3030 St. Joseph Avenue | Formal Review | Minor Zoning Amendment | Orleans Heights Development (Torgan Group); Fotenn Planning + Design; rla Architecture.

LEVEL GROUND FLOOR

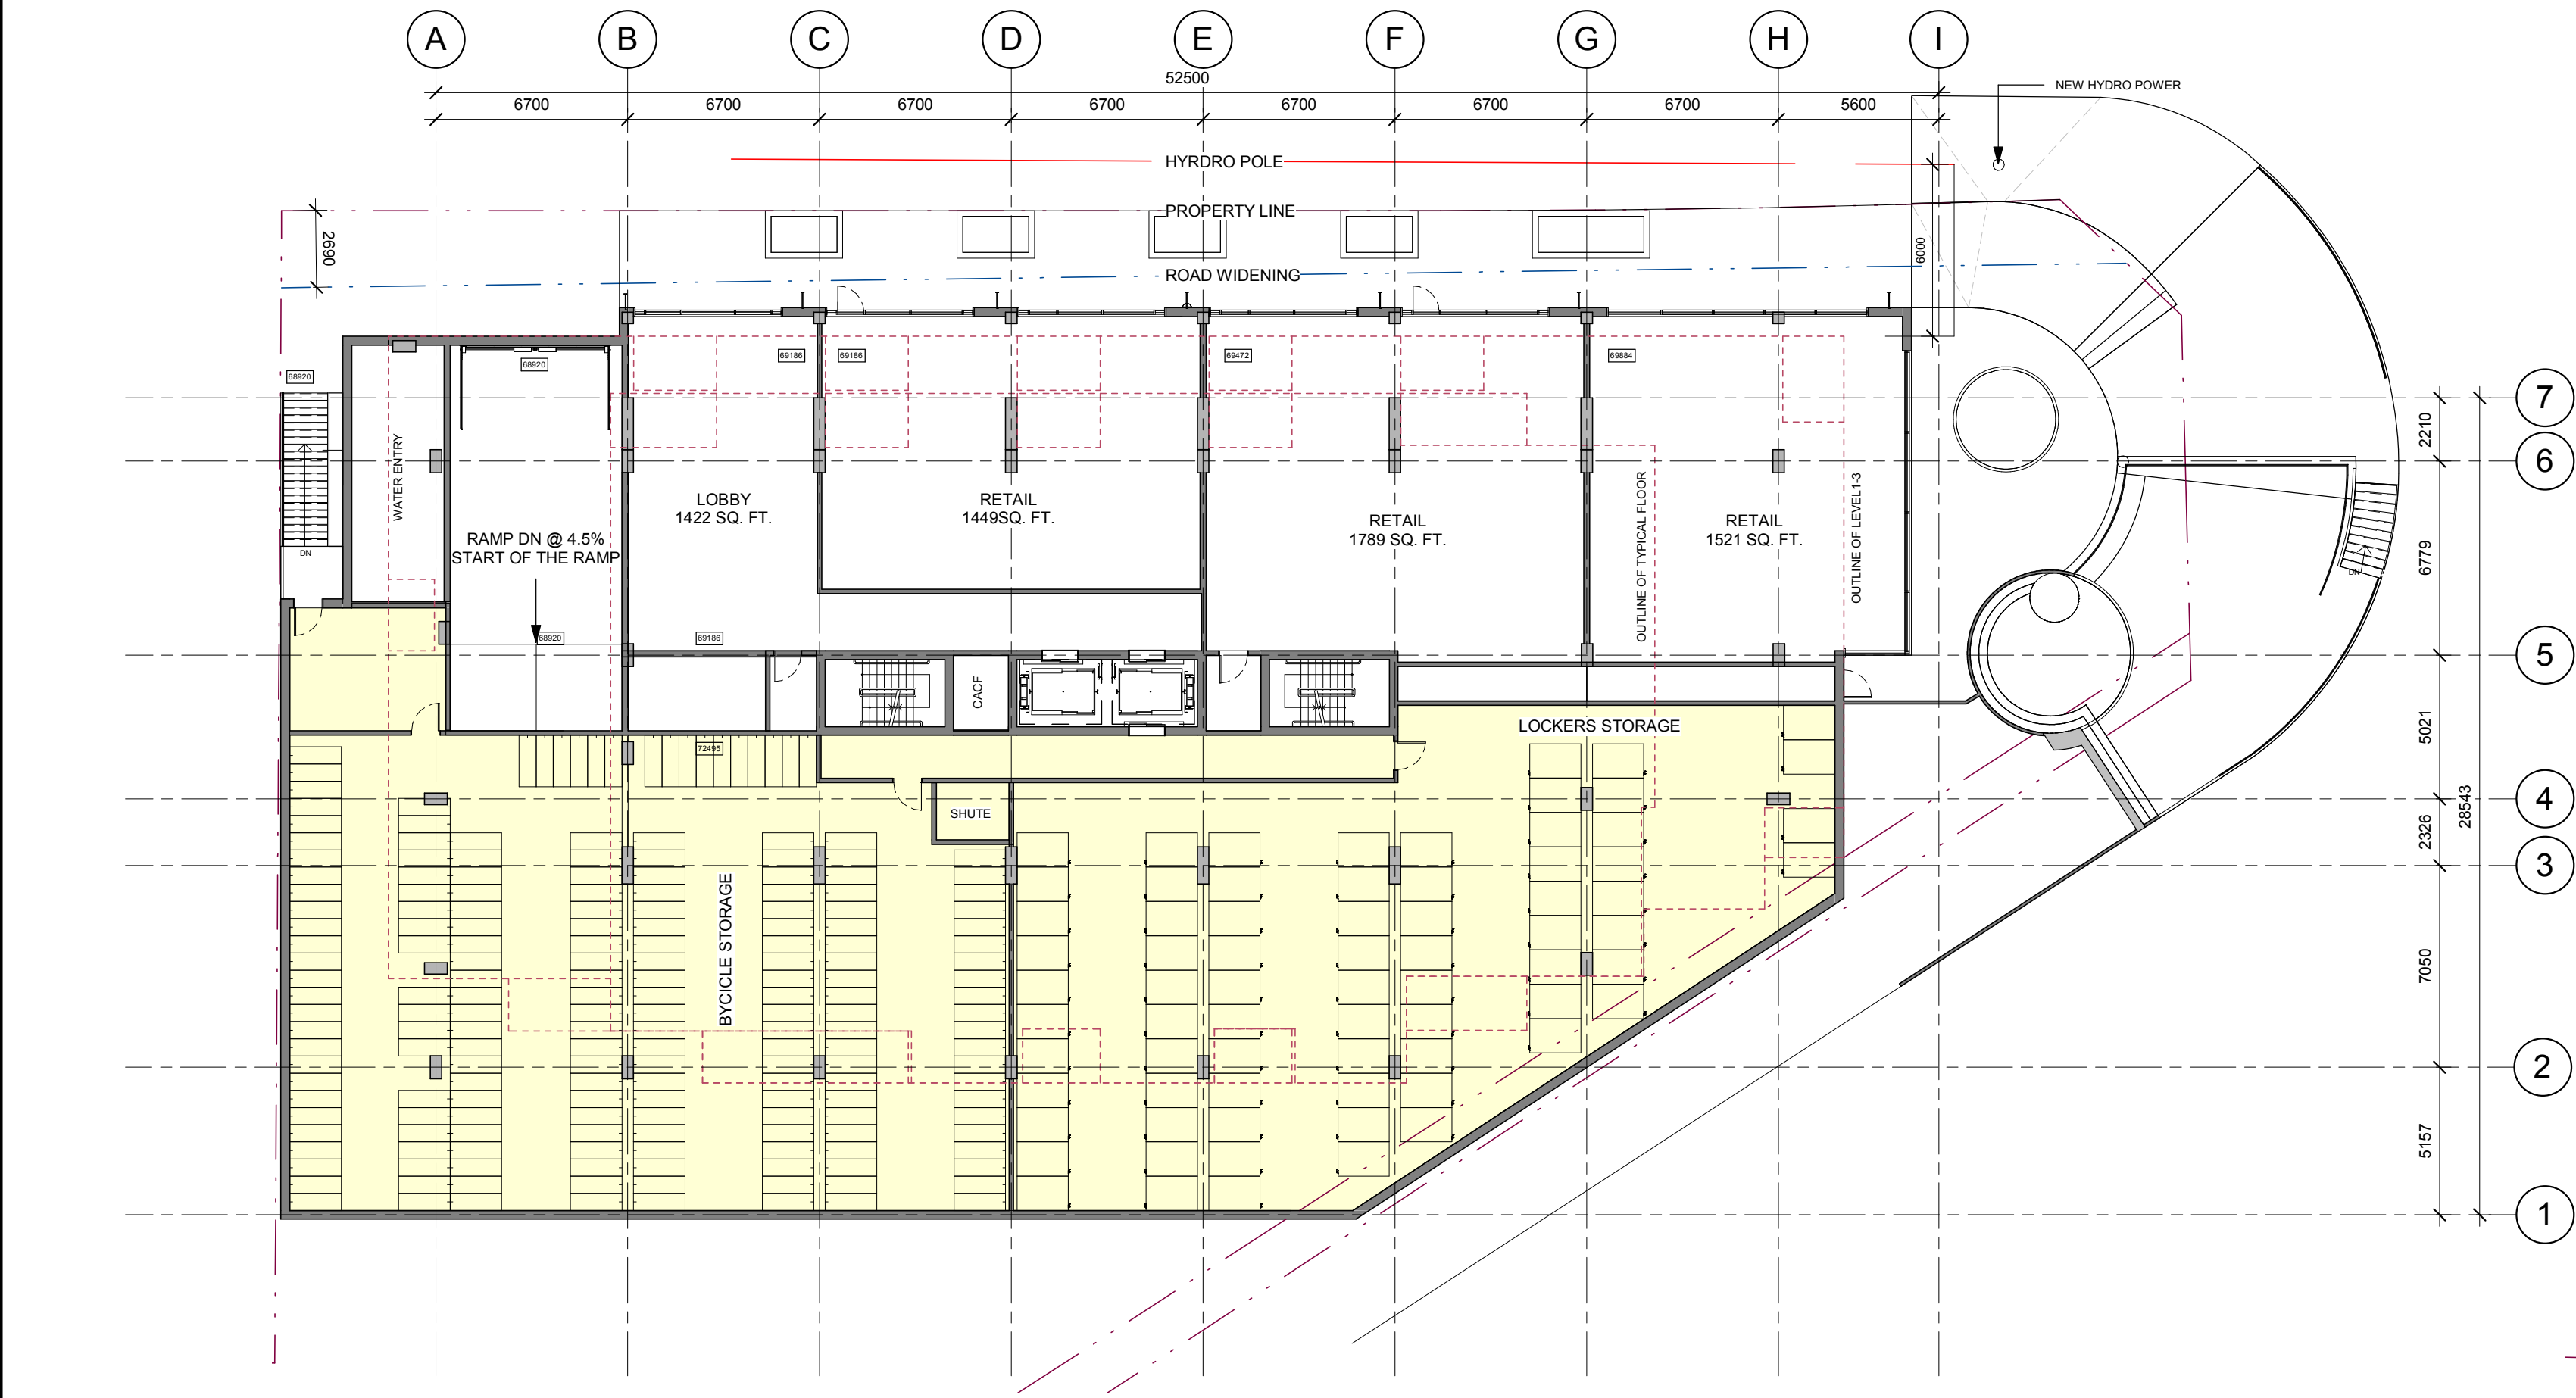
- The Panel suggests moving the lobby to the far west of the building along St. Joseph Boulevard as to avoid breaking up the retail space.
- Given the substantial change in grade, special attention must be paid to the interaction between the sidewalks and the building, particularly where wrapping around the corner.

NORTH ELEVATION

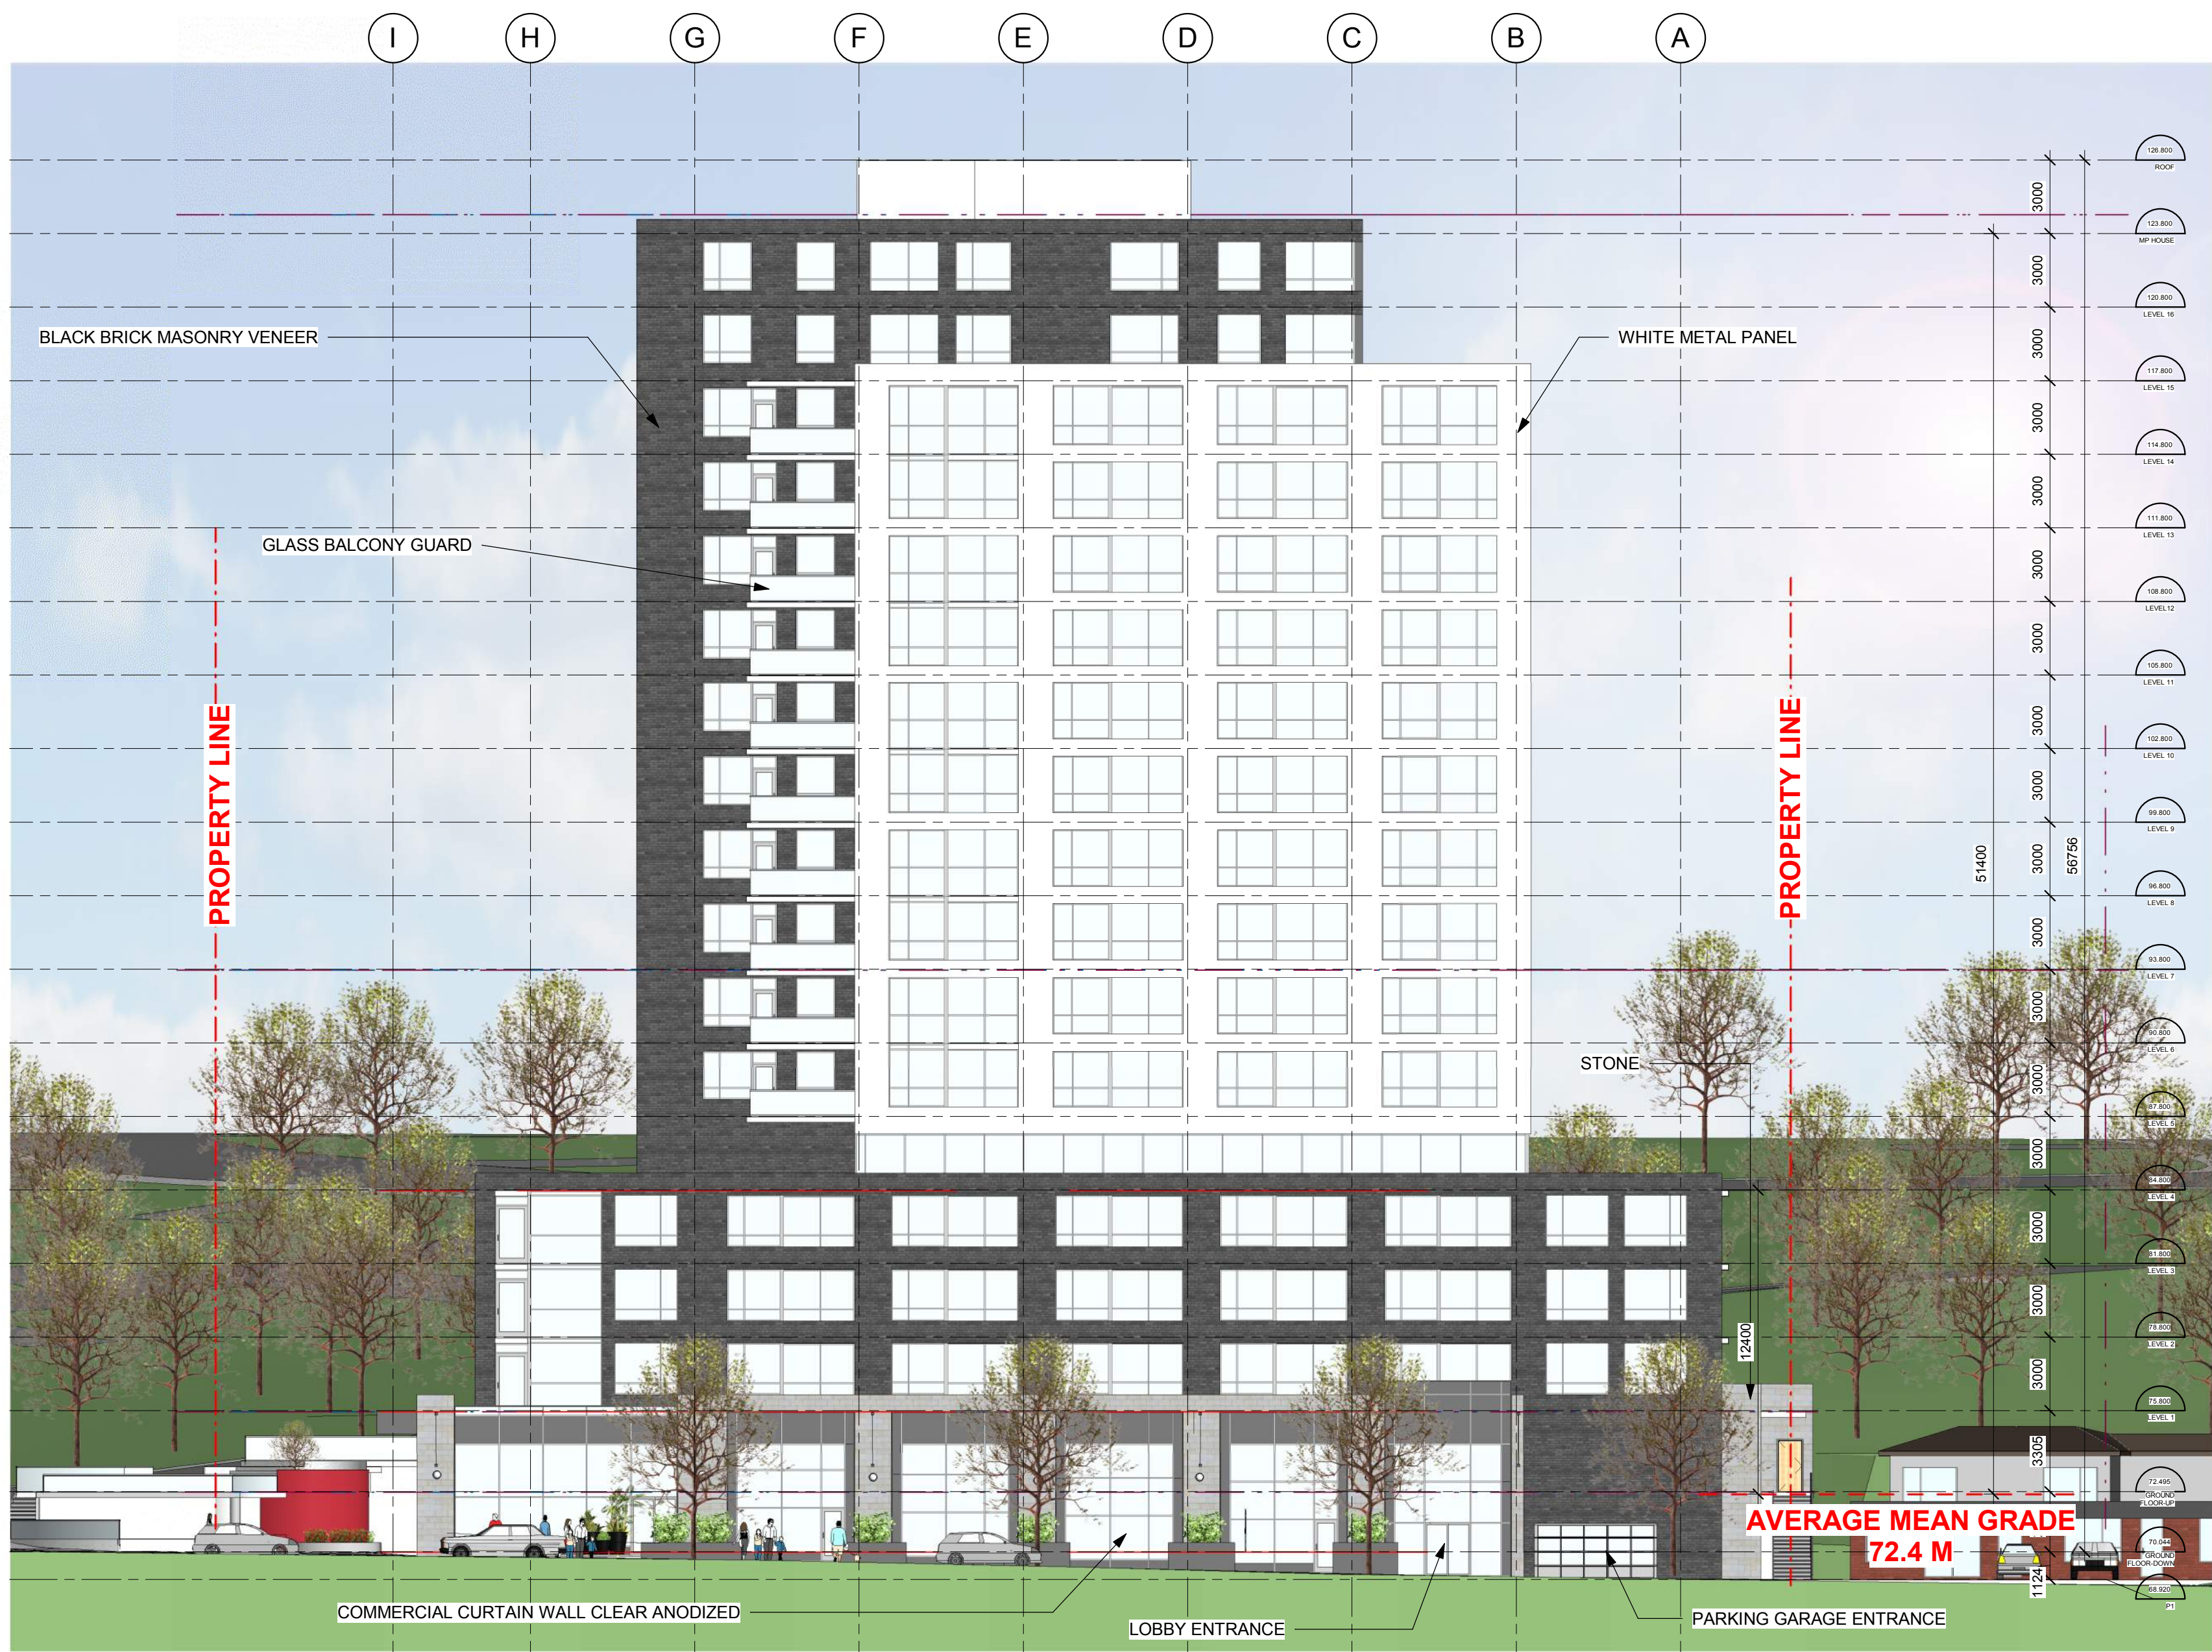
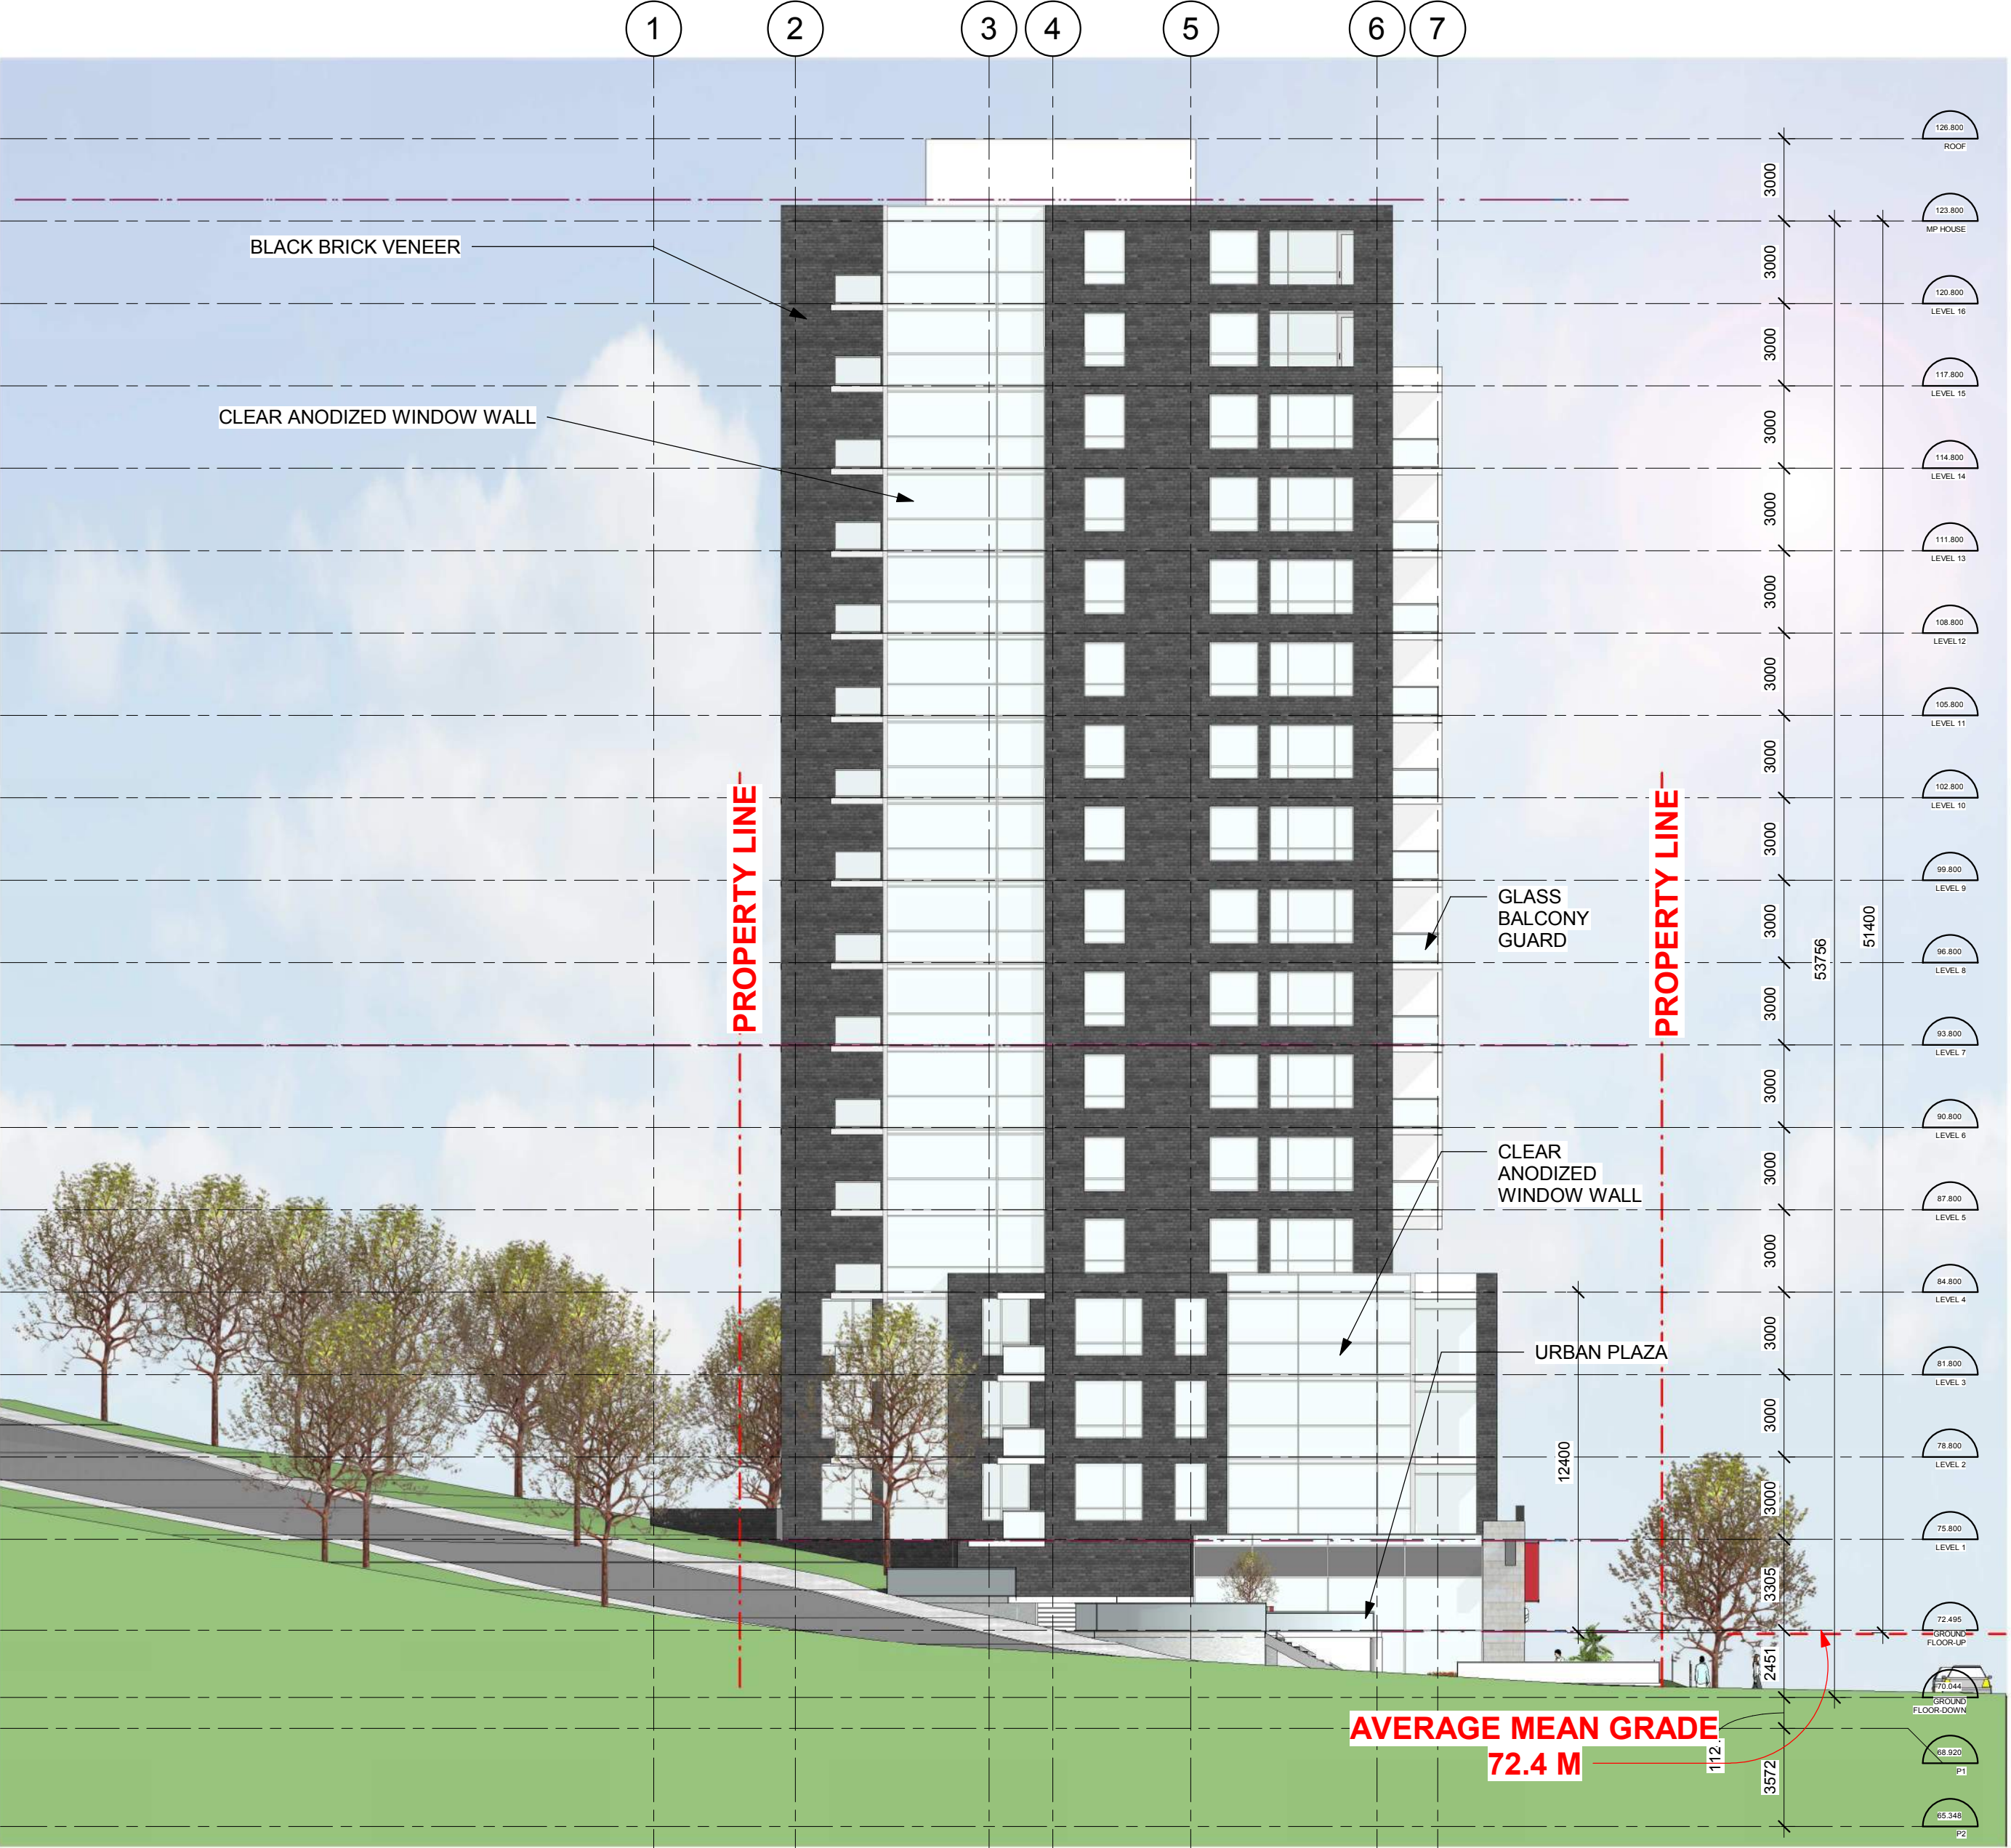
- When considering the top floor amenity, and the St. Joseph Boulevard elevation, the Panel sees this as a 14-storey building. It is the opinion of the Panel that the proposal represents overbuilding of the site, and recommends that eight stories is the maximum height in order for the building to fit its context at the edge of a low-density residential neighbourhood.
- The Panel suggests that the tower portion of the building fronts St. Joseph Boulevard, with a lower podium located along Duford Drive, thereby shifting density away from the residential side of the lot. The current distribution of massing results in an imposition to the established residential area to the south.
- The Panel suggests that the corner element of the building could be redesigned to be more slender.
